Our ref. TE/B0158/18
PP ref. PP-07277766

BUTLINS RESORT, BOGNOR REGIS

S.73 Application for variation of a condition following grant of planning permission

Original planning application ref. BR240/16/PL

job: 5128 dwg: P201 rev: D

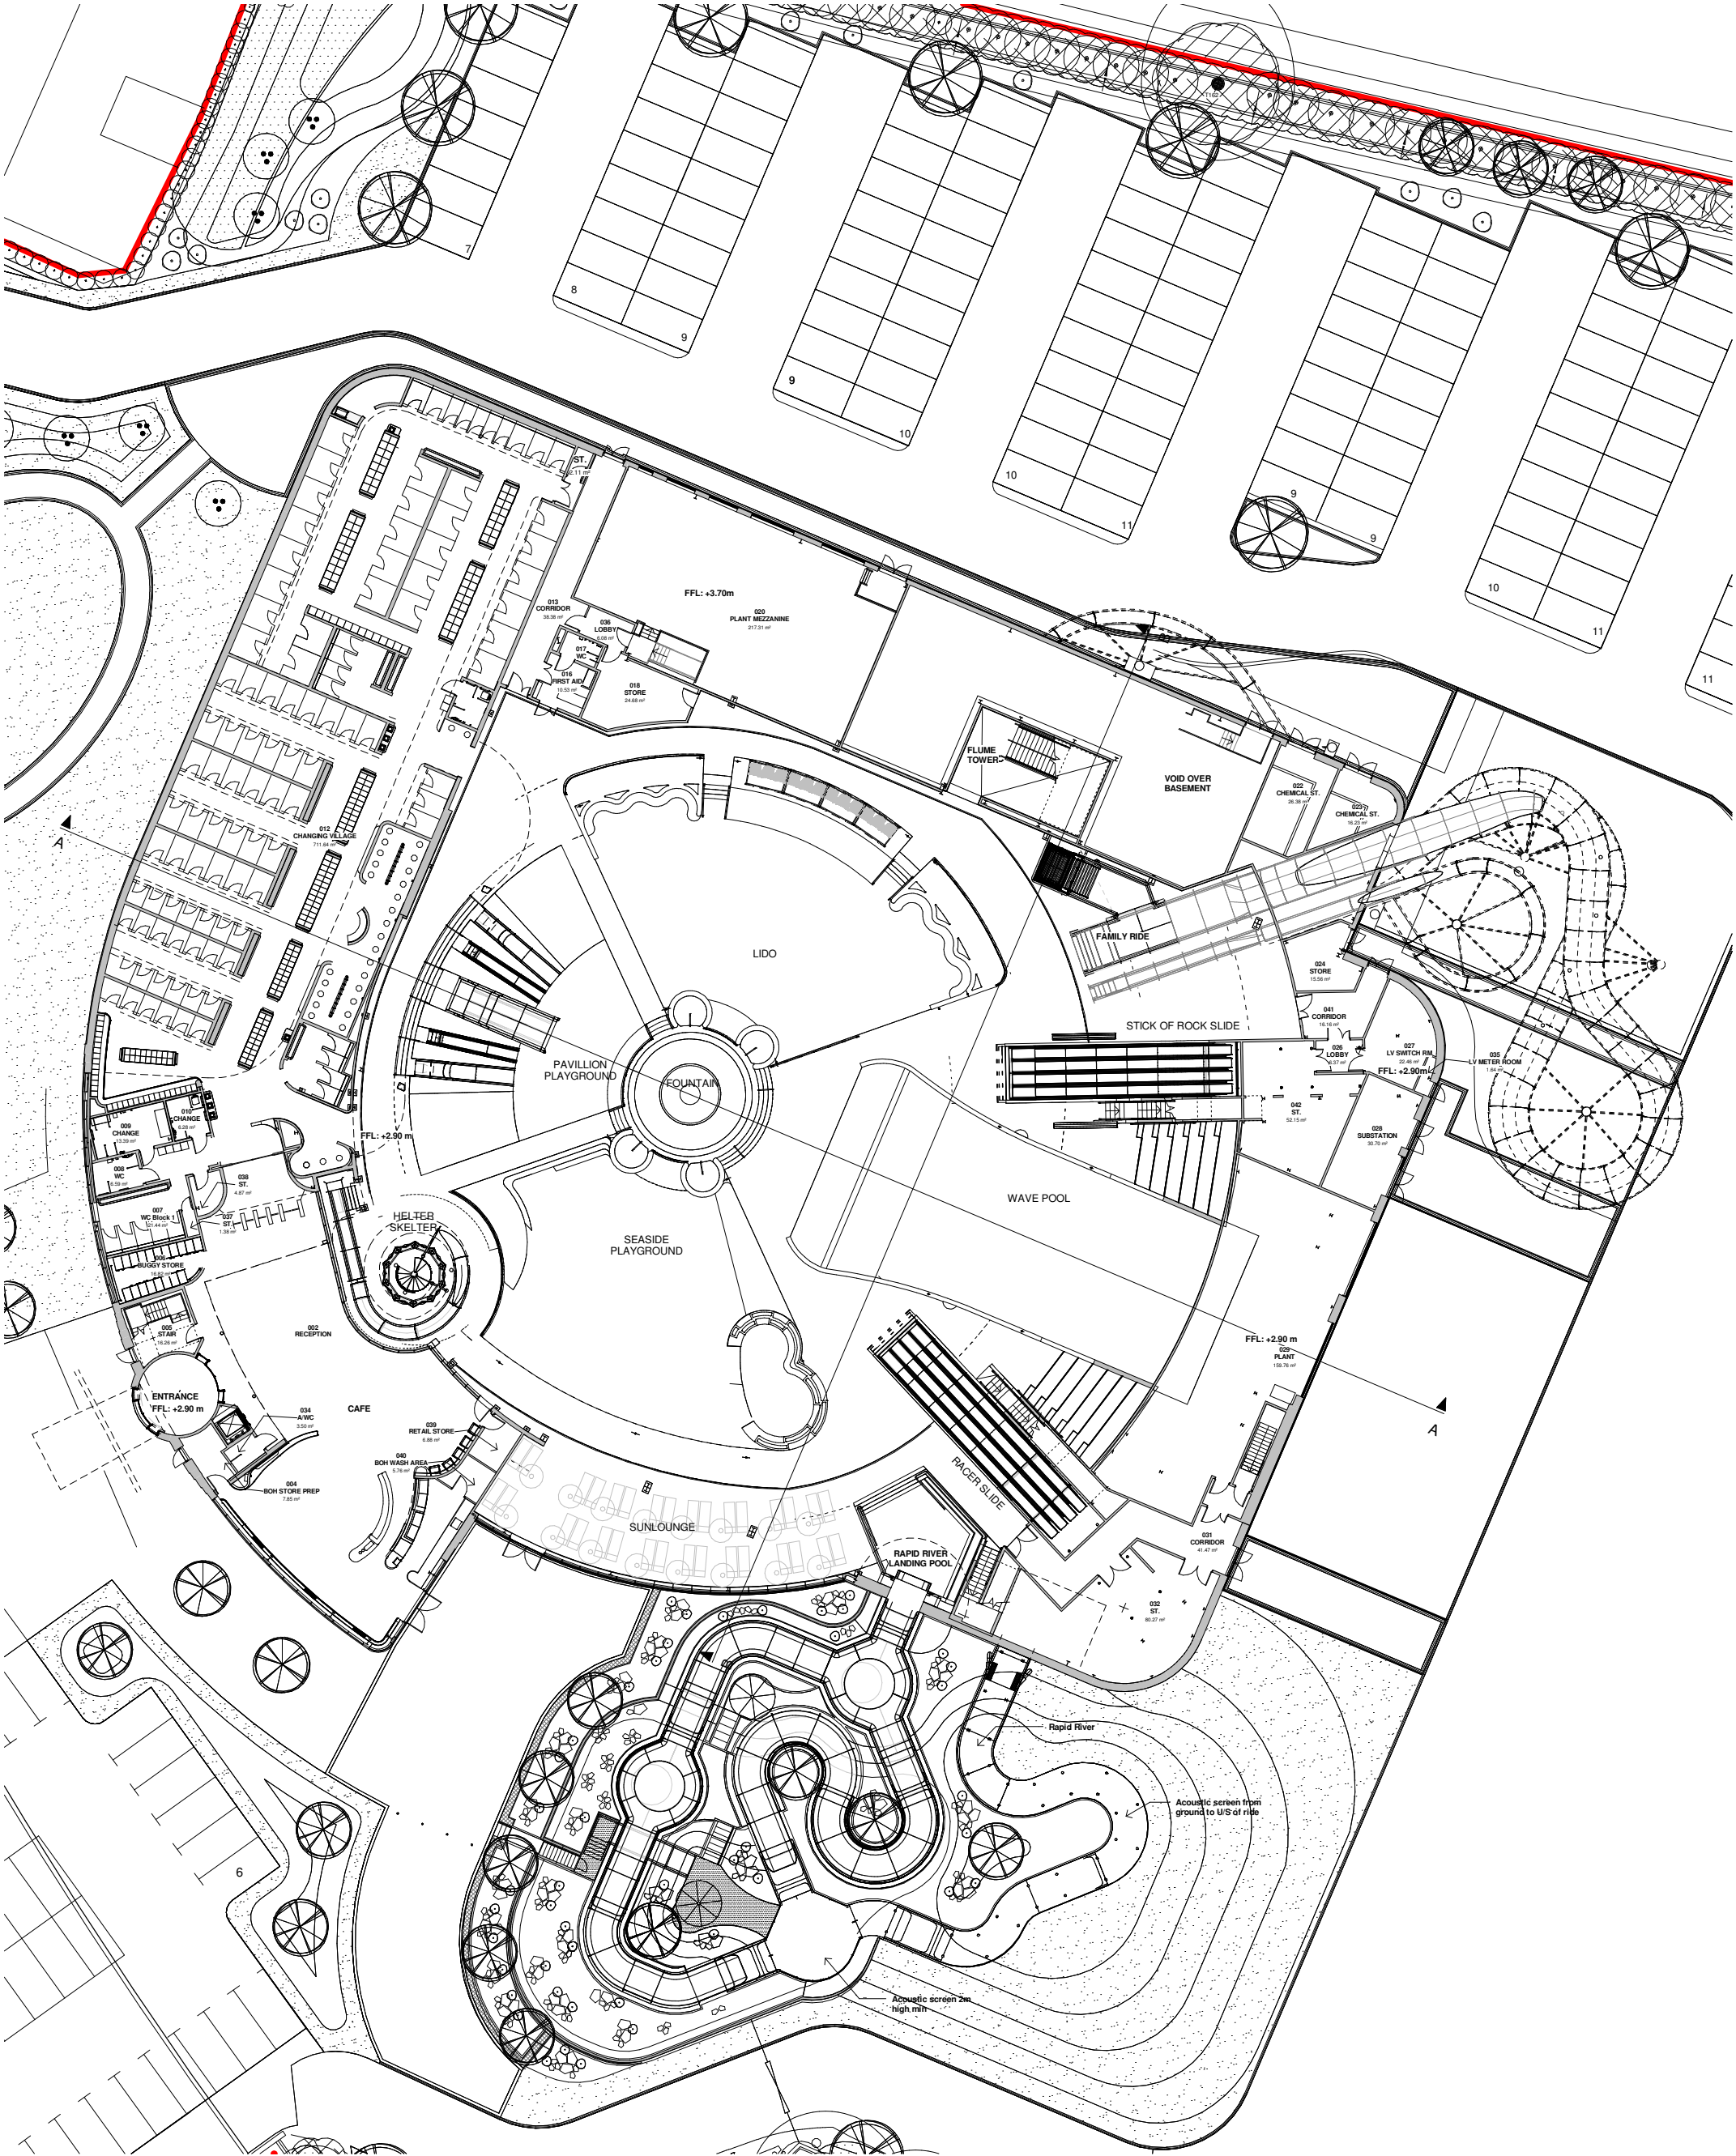
This application proposes minor material amendments to reduce the height of the flume tower, adjust the design of the rapid river ride, changes to the landscaping and promenade, removal of some windows and rooflights, changes to doors, adjustments to some of the proposed materials, and the addition of louvres.

- 5128 P200 Rev B Basement Floor Plan
- 5128 P201 Rev C Ground Floor Plan
- 5128 P202 Rev C First Floor Plan
- 5128 P203 Rev B Roof Plan
- 5128 P300 Rev D Proposed Elevations Sheet 1
- 5128 P301 Rev D Proposed Elevations Sheet 2
- 5128 P305 Rev C Proposed Site Elevations
- 5128 P405 Rev B Proposed Sections

- 5128 P200 Rev C Basement Floor Plan
- 5128 P201 Rev D Ground Floor Plan
- 5128 P202 Rev D First Floor Plan
- 5128 P203 Rev C Roof Plan
- 5128 P300 Rev E Proposed Elevations Sheet 1
- 5128 P301 Rev E Proposed Elevations Sheet 2
- 5128 P305 Rev D Proposed Site Elevations
- 5128 P405 Rev D Proposed Sections

job: 5128  
dwg: 1301  
rev: M

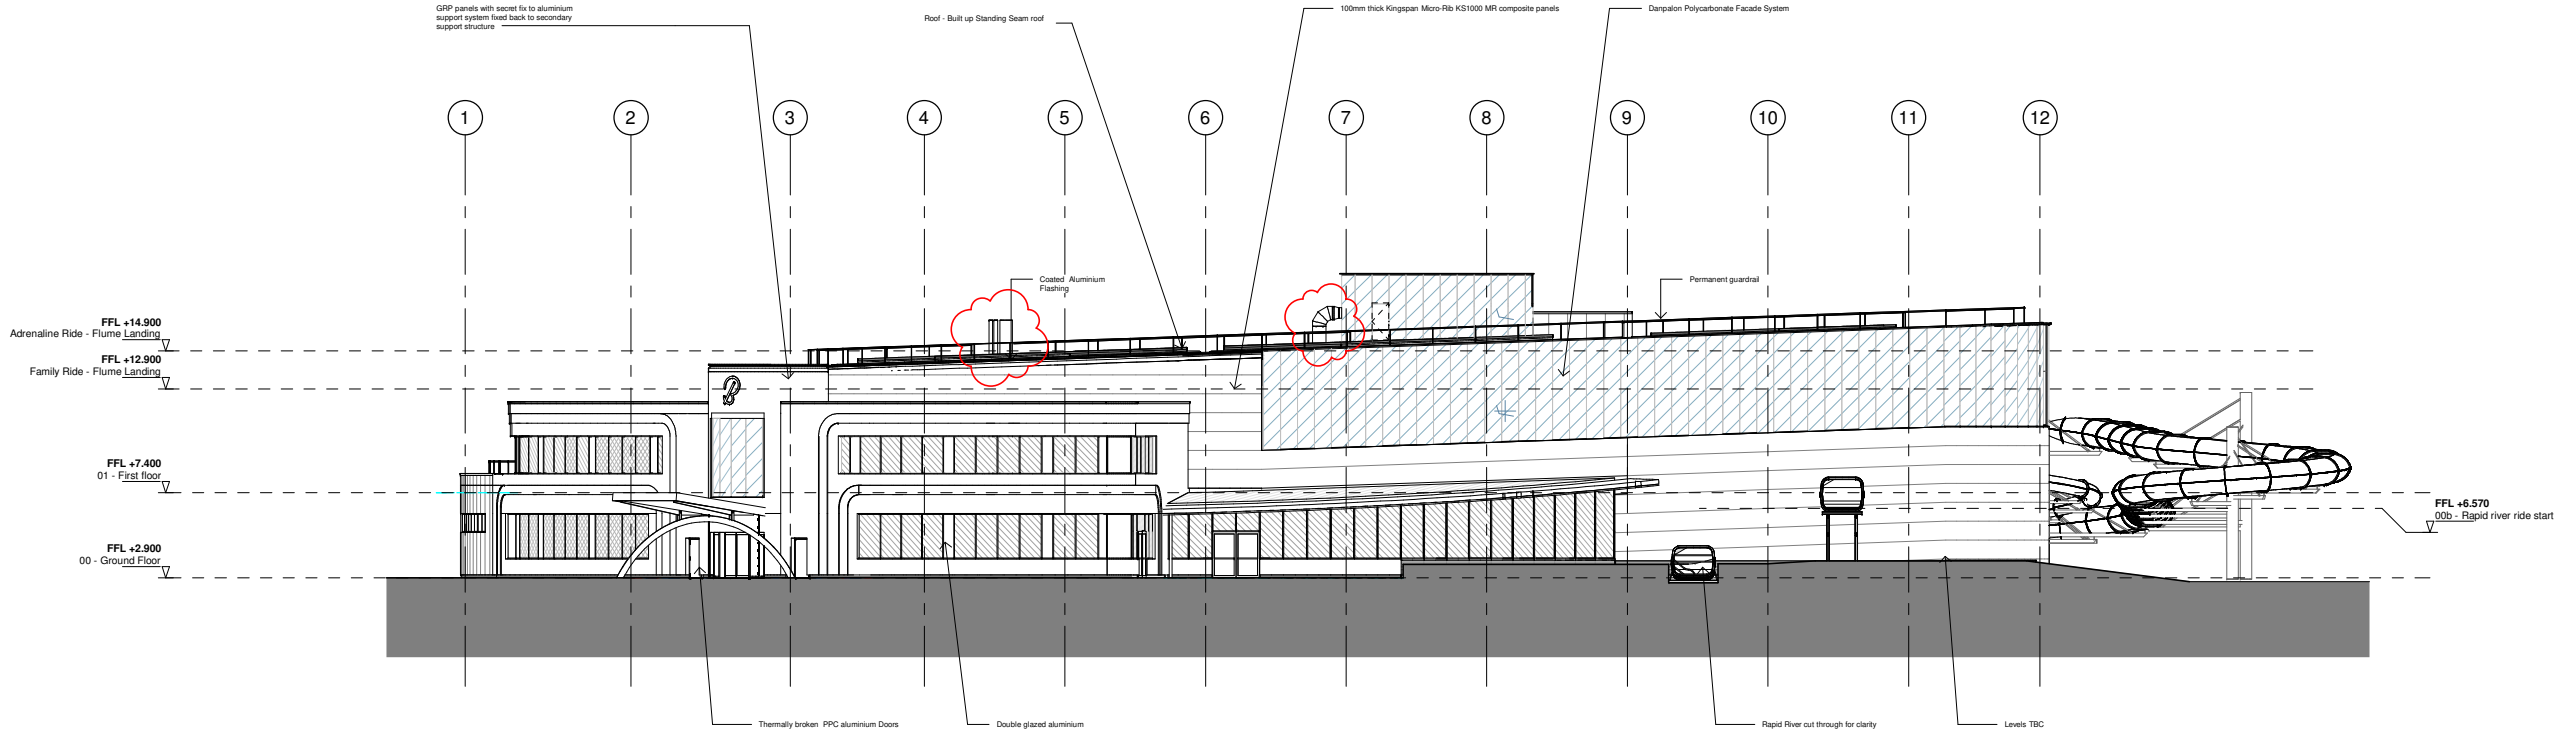
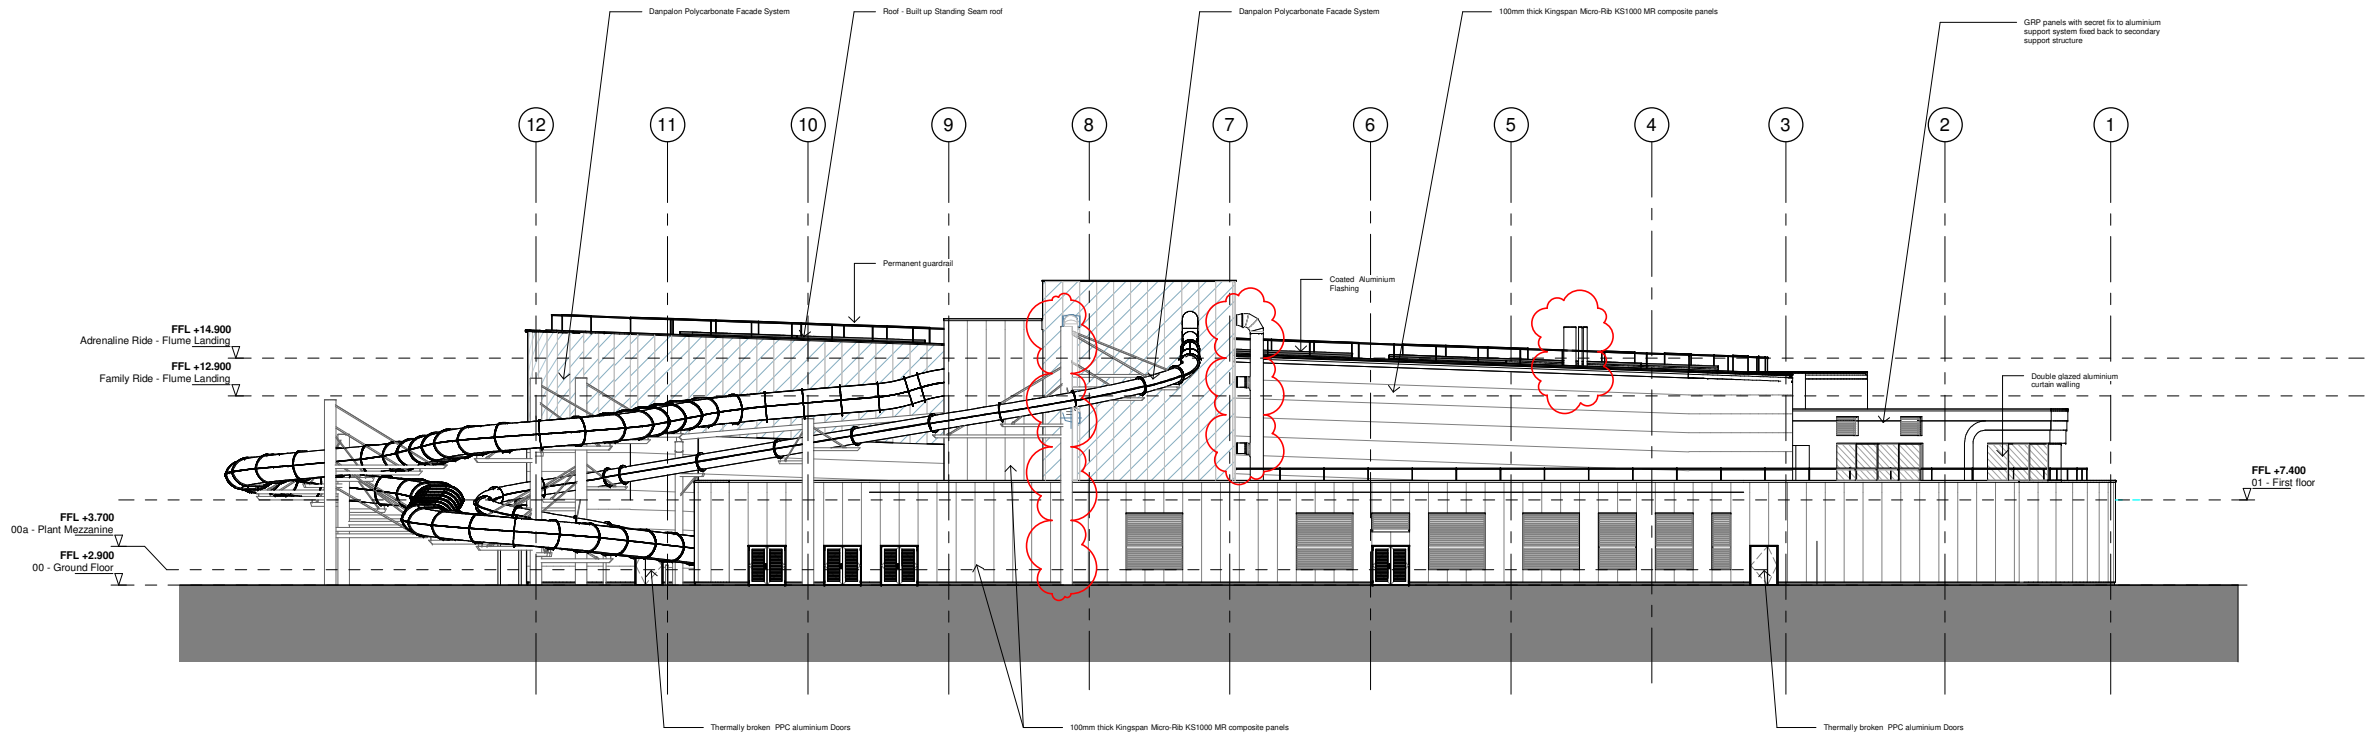
The following **proposed** drawings are to be added to the decision notice (they are not substitutions). They show the flues and louvres amendments highlighted as clouds on the drawings for ease of reference:

- 5128 1301 Rev M Elevations – sheet 1
- 5128 1302 Rev M Elevations – sheet 2
- 5128 1303 Rev D North Elevation – sheet 1
- 5128 1304 Rev E North Elevation – sheet 2
- 5128 1305 Rev D South Elevation – sheet 1
- 5128 1306 Rev B South Elevation – sheet 2
- 5128 1307 Rev C East Elevation
- 5128 1308 Rev C Entrance and Cafe Elevation
- 5128 1309 Rev C West Elevation – sheet 1
- 5128 1310 Rev B West Elevation – sheet 2
